Our Ref: K/26/18/HH

**Town & Country Planning Act 1990 (as amended)
Town & country Planning (Development Management Procedure) (England) Order 2015
Application for Planning Permission for Works or Extension to a Dwelling**

Development Two storey rear extension
Location 87 Golden Avenue East Preston

REAR ELEVATION

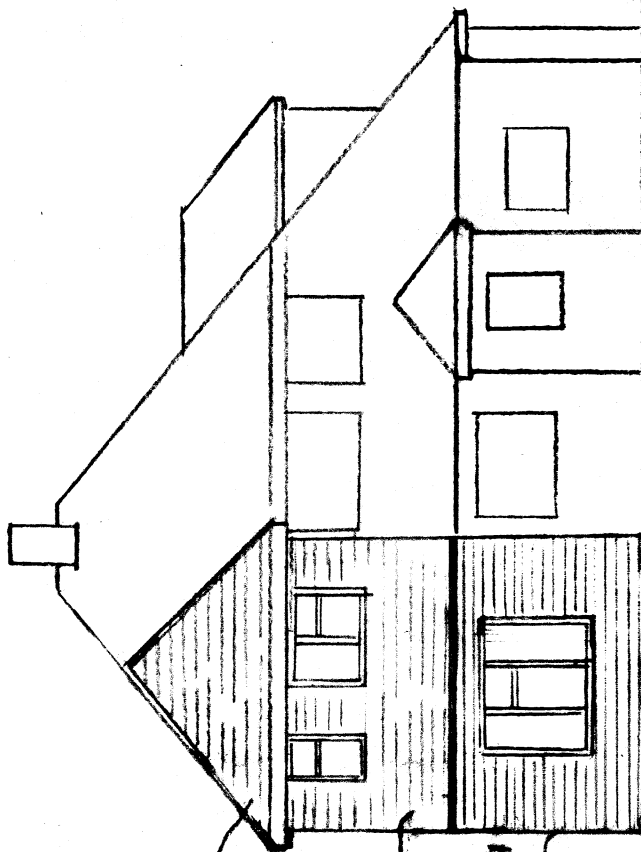
The ground floor plan and rear elevation do not accord. Please amend accordingly.

BLOCK PLAN Scale 1:500

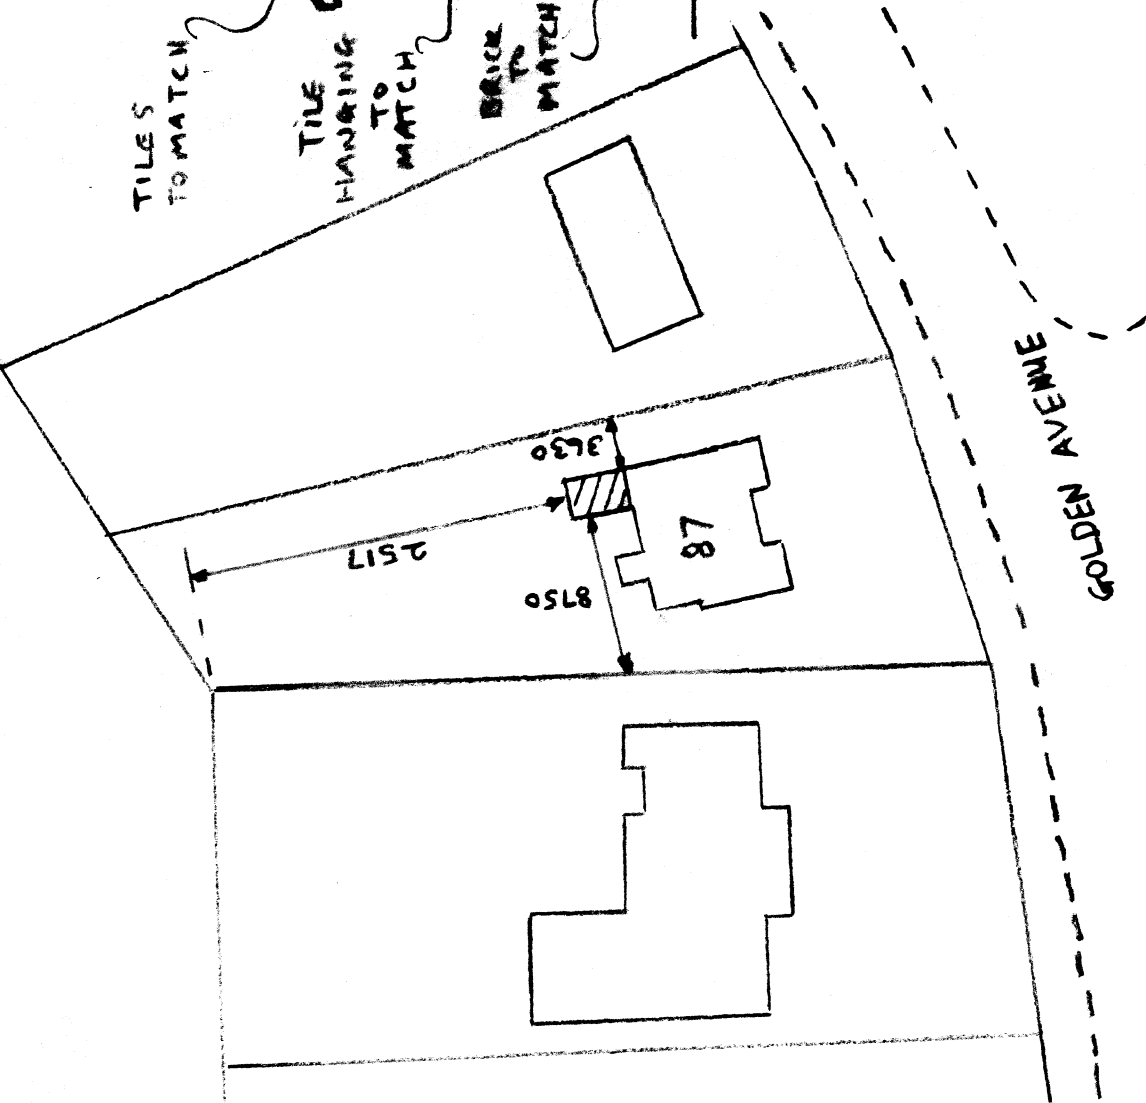
Block Plan Amend

Please provide measurements from the proposal to the site boundaries.
